ENG-SF20015-R2-GEC-redlines.pdf Markup Summary

ENGINEERING REVIEW COMMENT CONTROL PLAN

CDR-20-005

SF-20-015

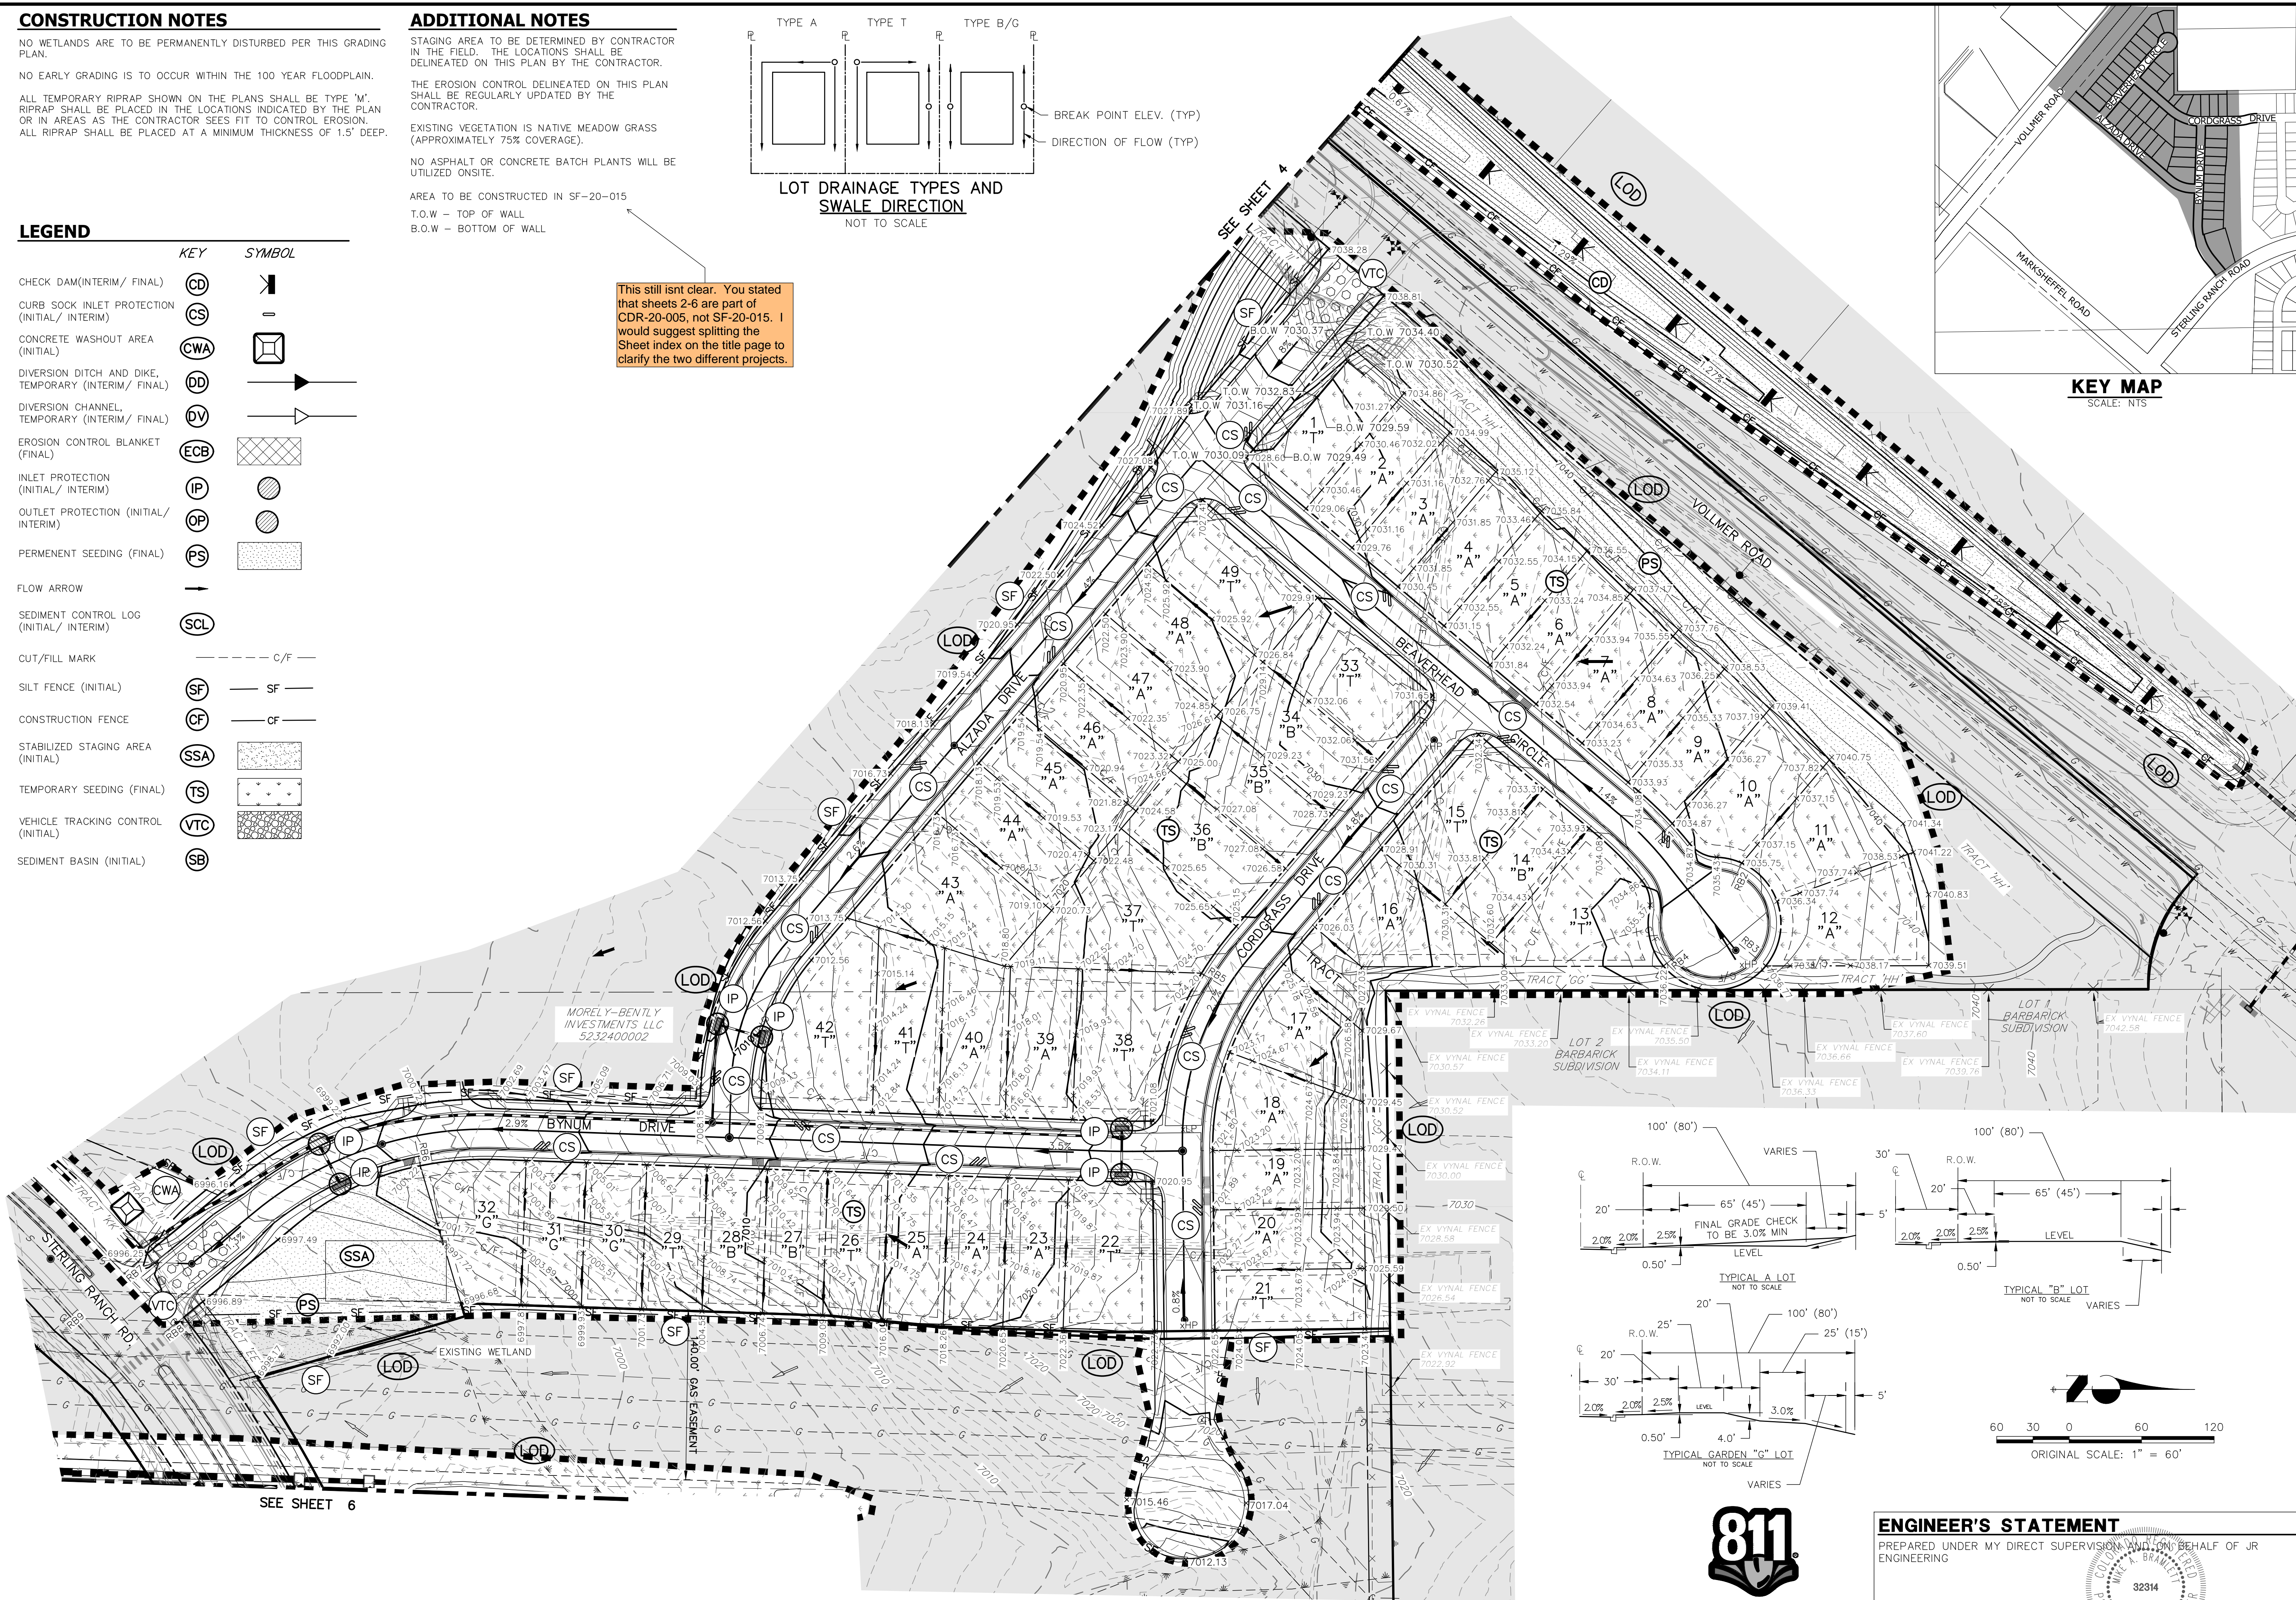
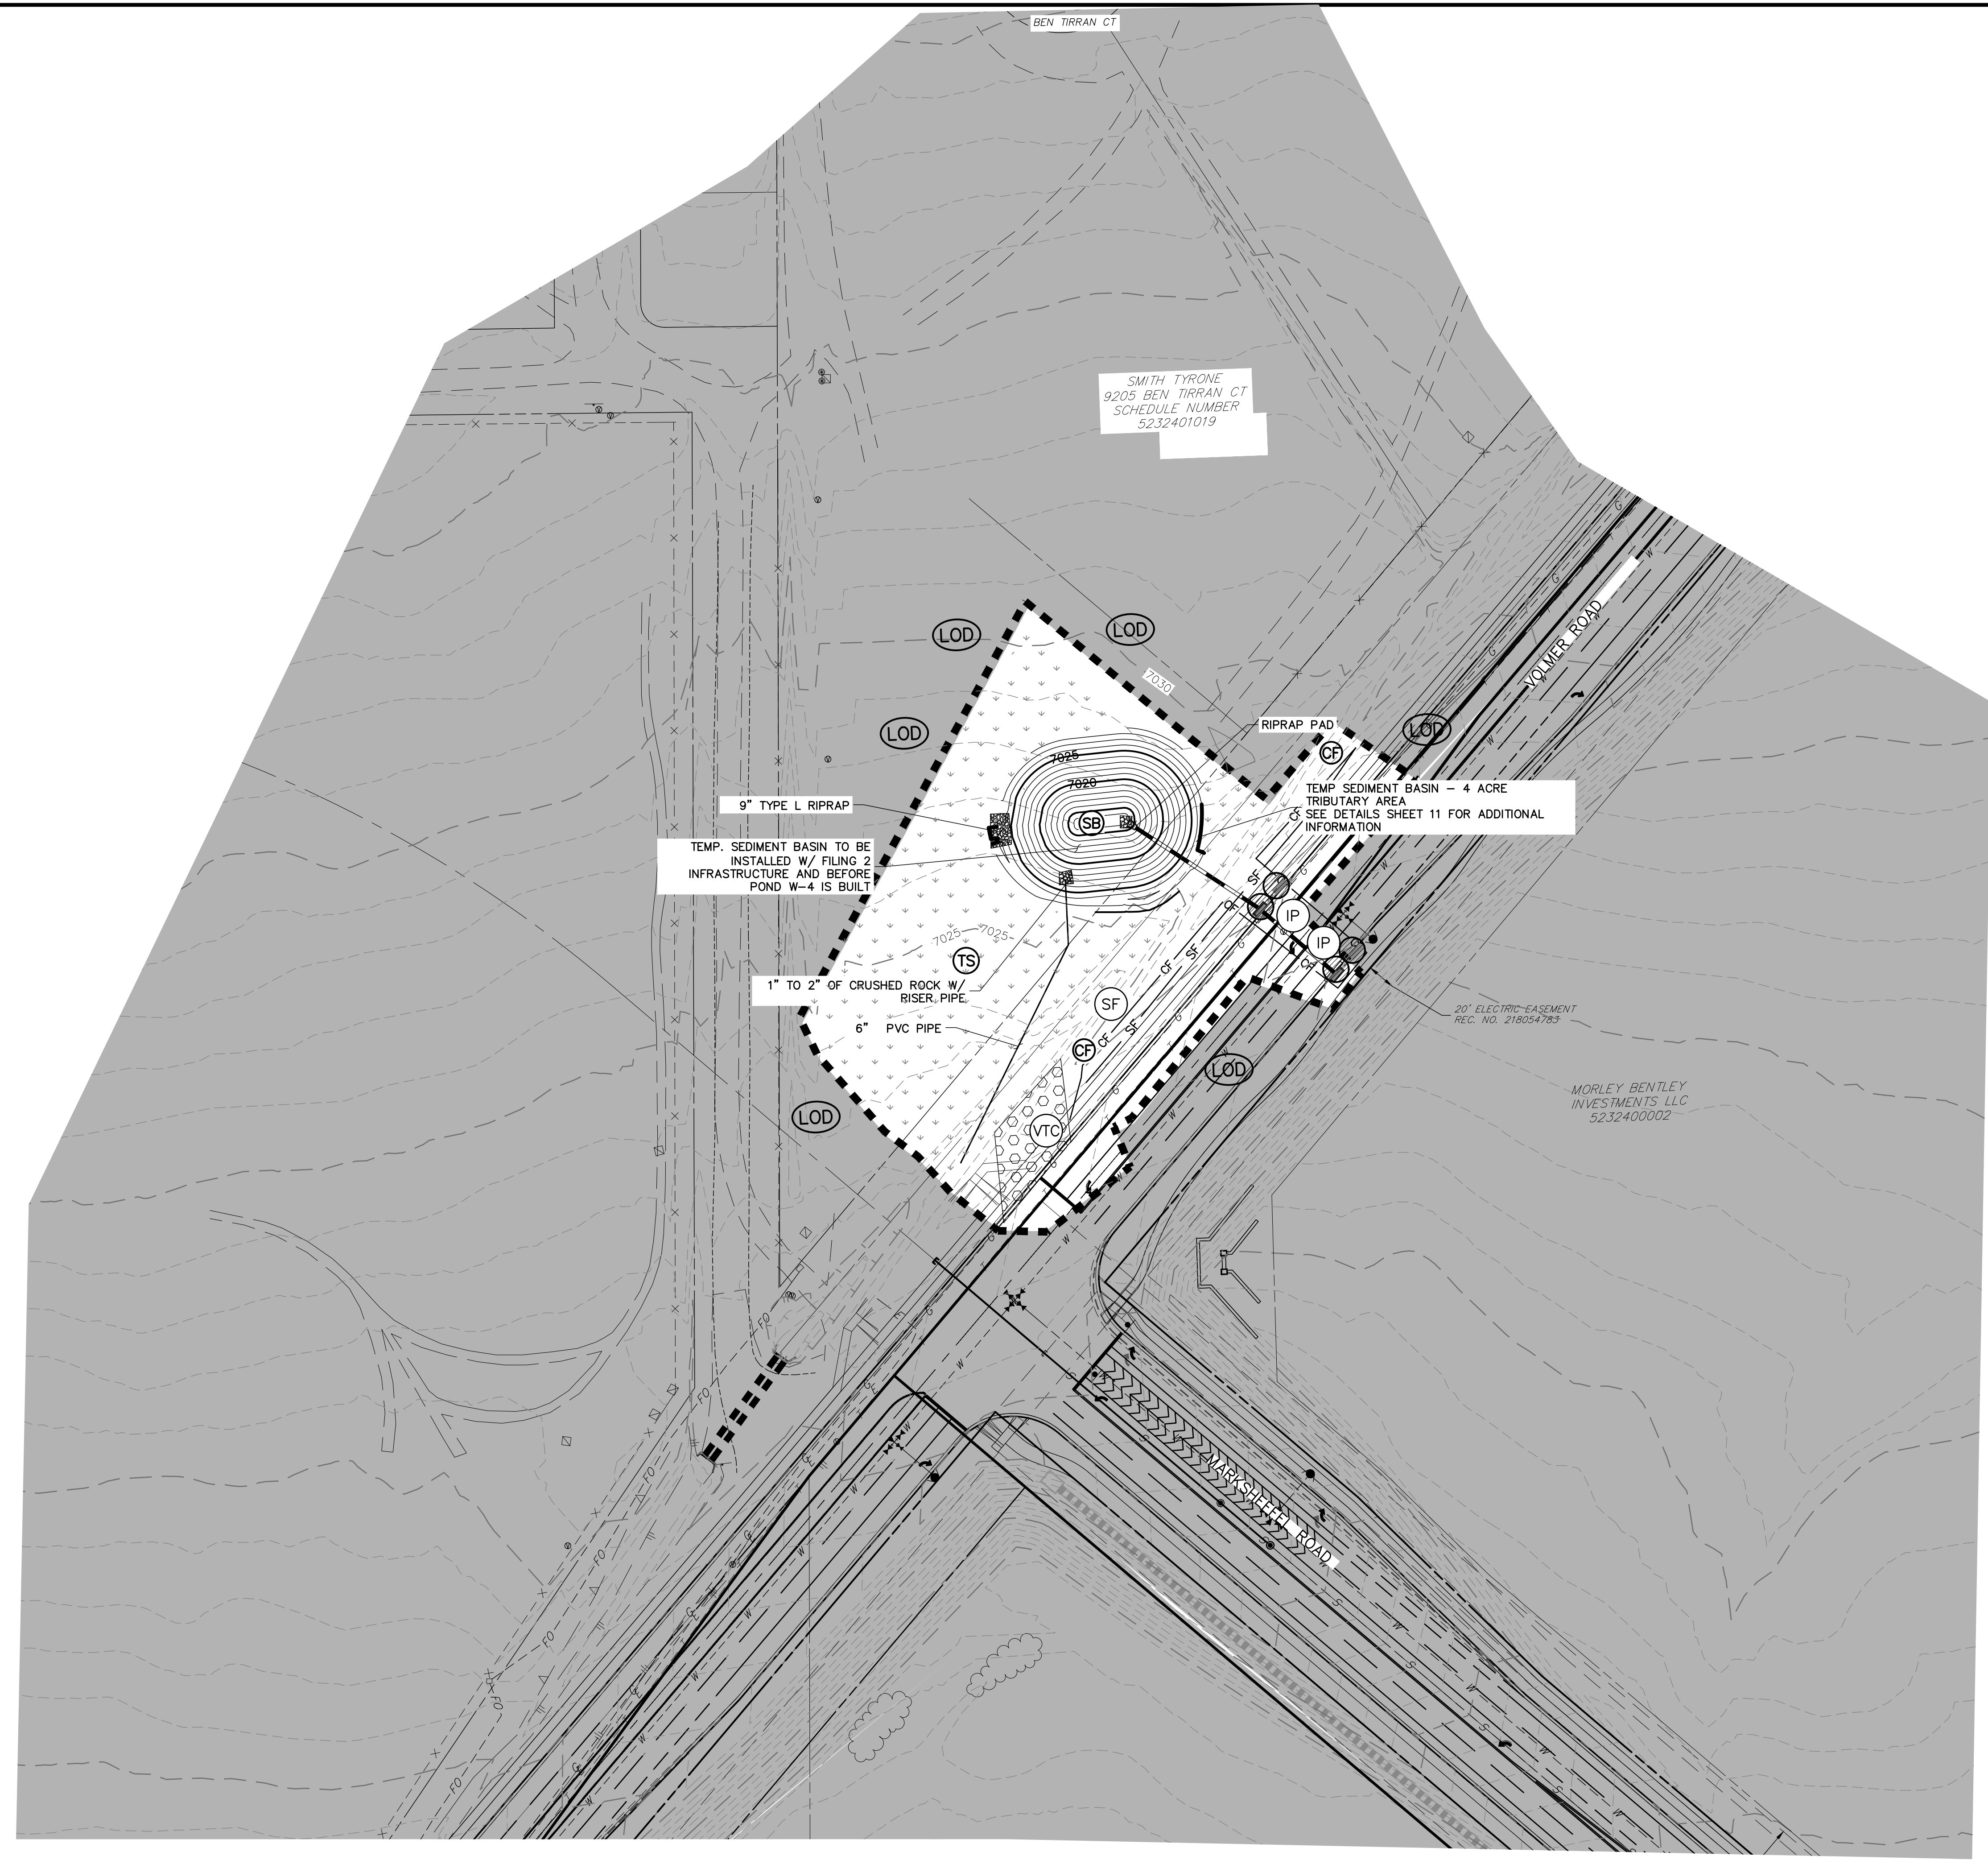
define in legend
Unresolved.

Sediment Basins should be Initial/Interim.

Show Sediment basin locations and contours, and provide details for each temporary sediment basin, including riser pipe perforation sizing, number of rows, required volume, and tributary area to the sediment basin.
Unresolved.

Call out areas of work covered under CDR-20-005, not to be completed under SF-20-015

please show cut/fill lines on legend. Unresolved.

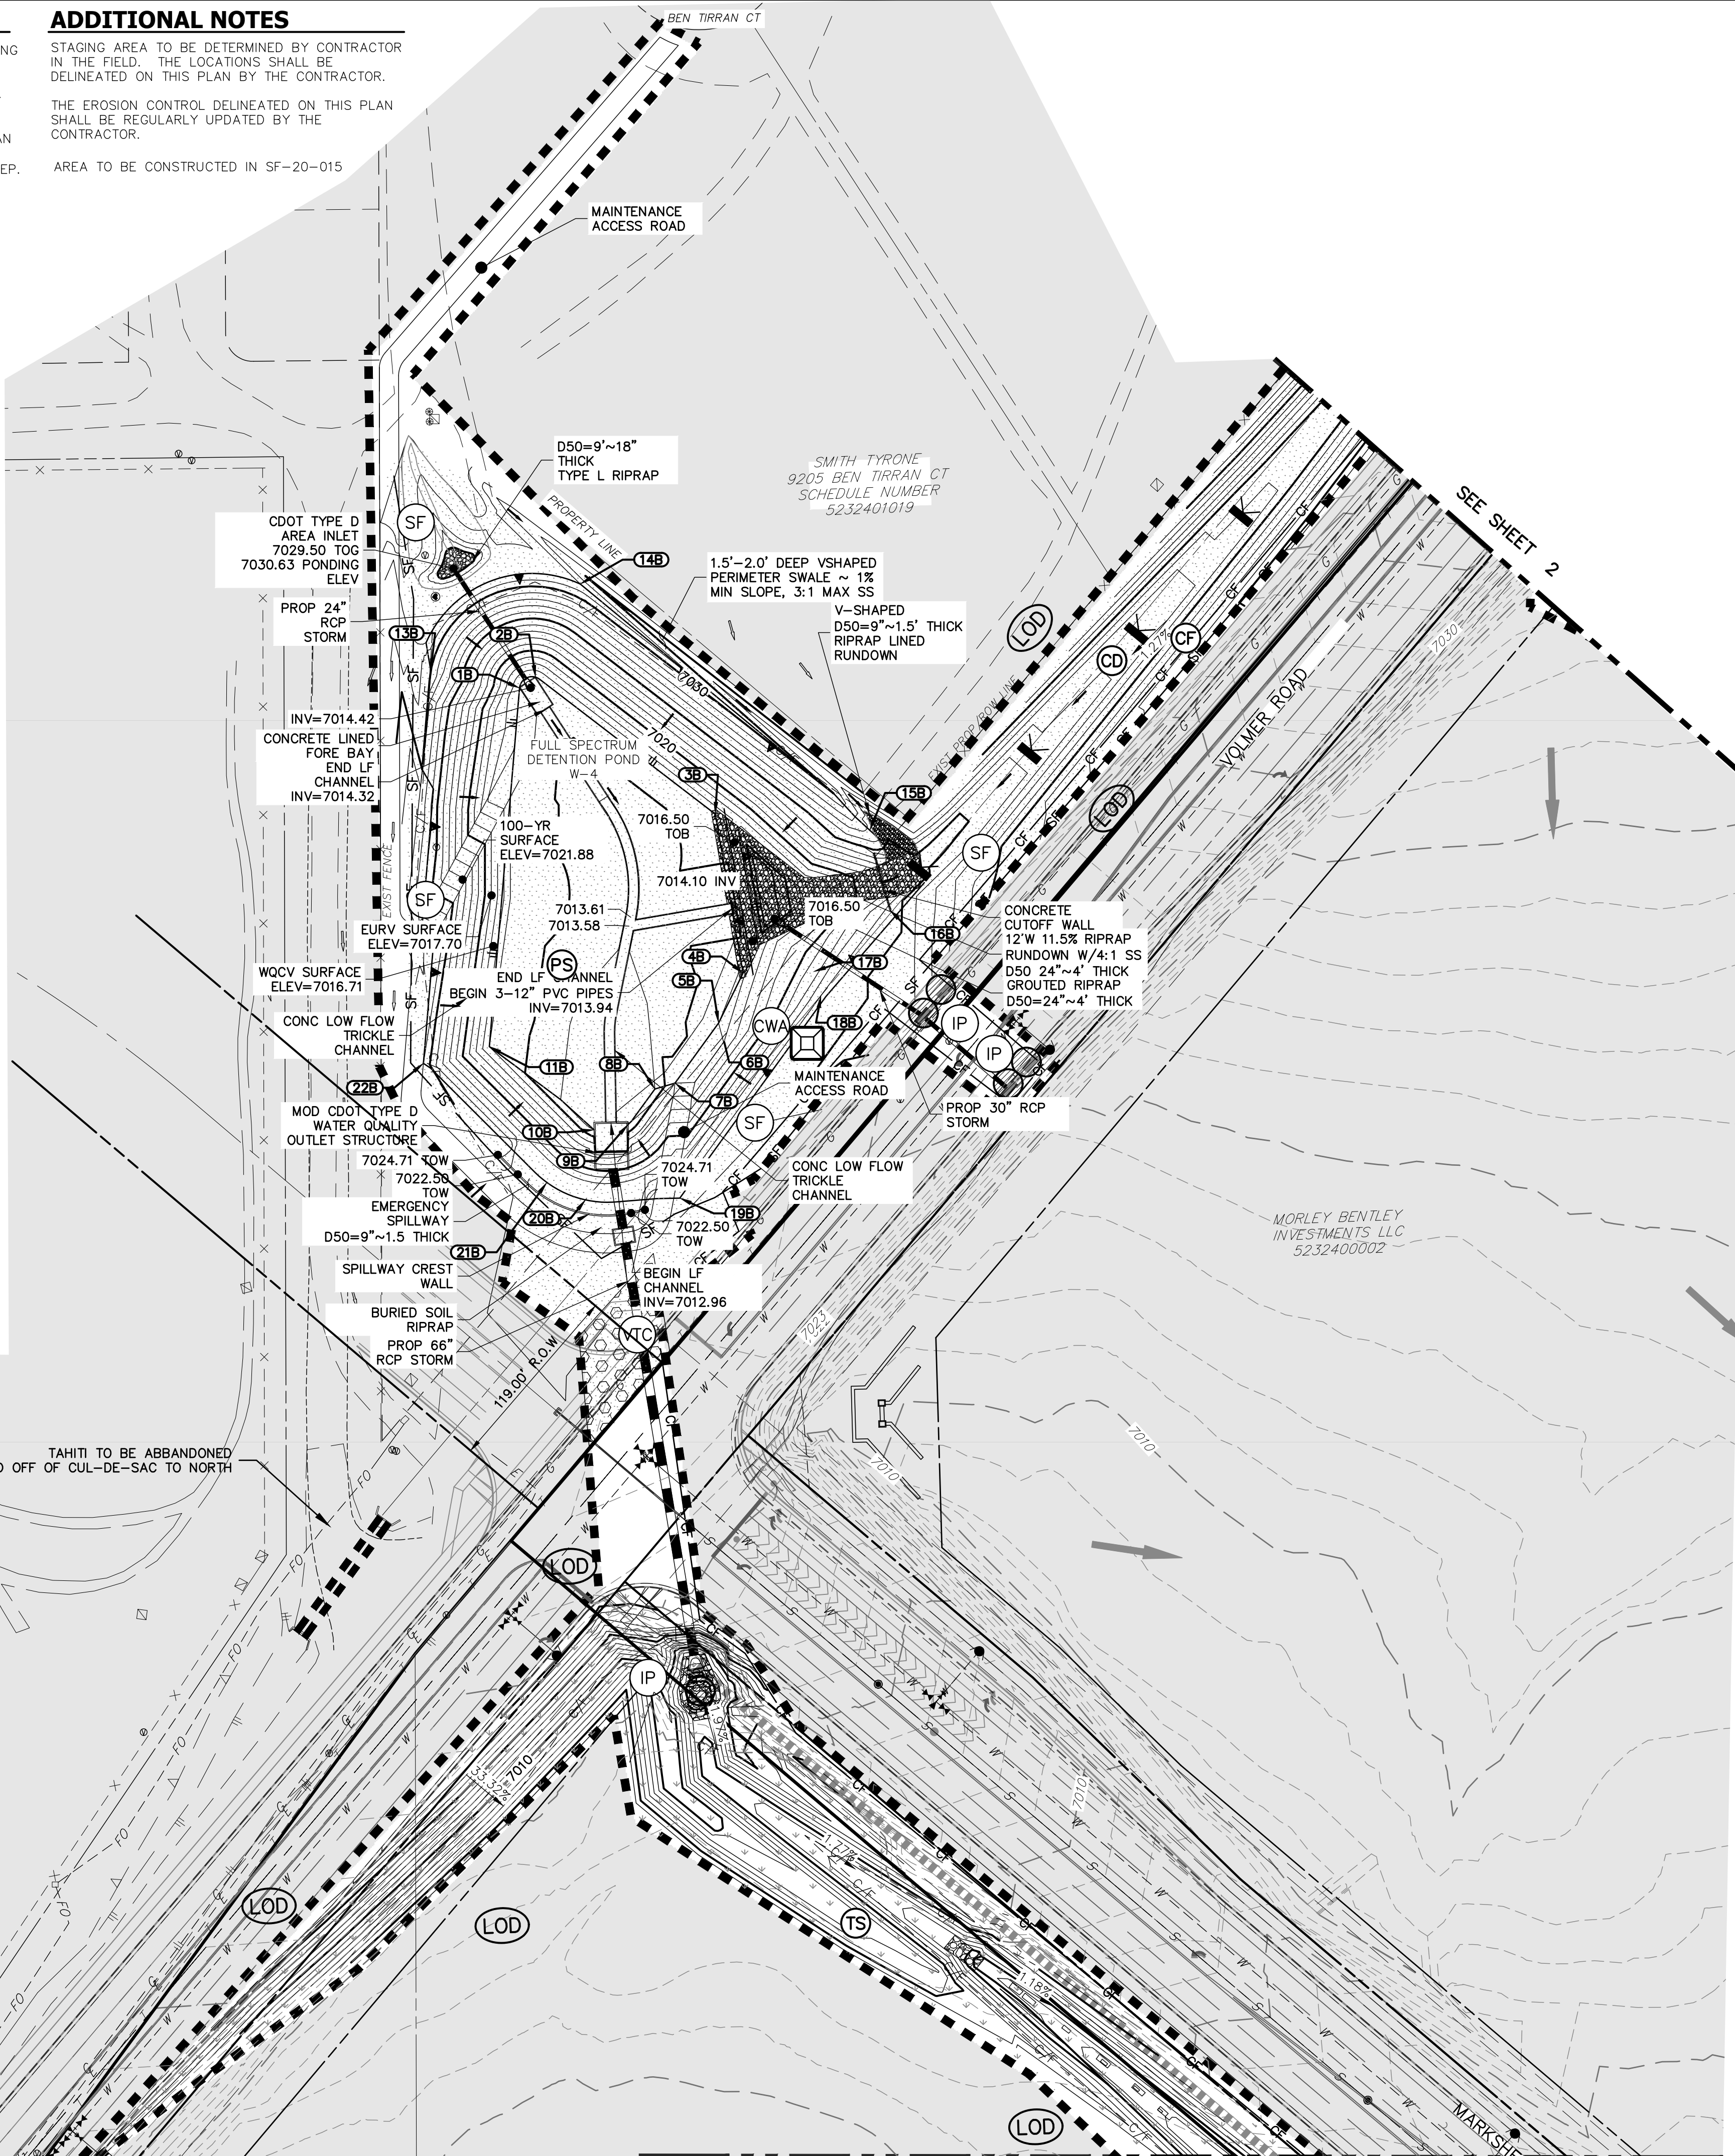
show construction fence in legend

Is scale correct?

ROW doesn't seem wide enough for turn lanes...

CWA should be away from the ditch
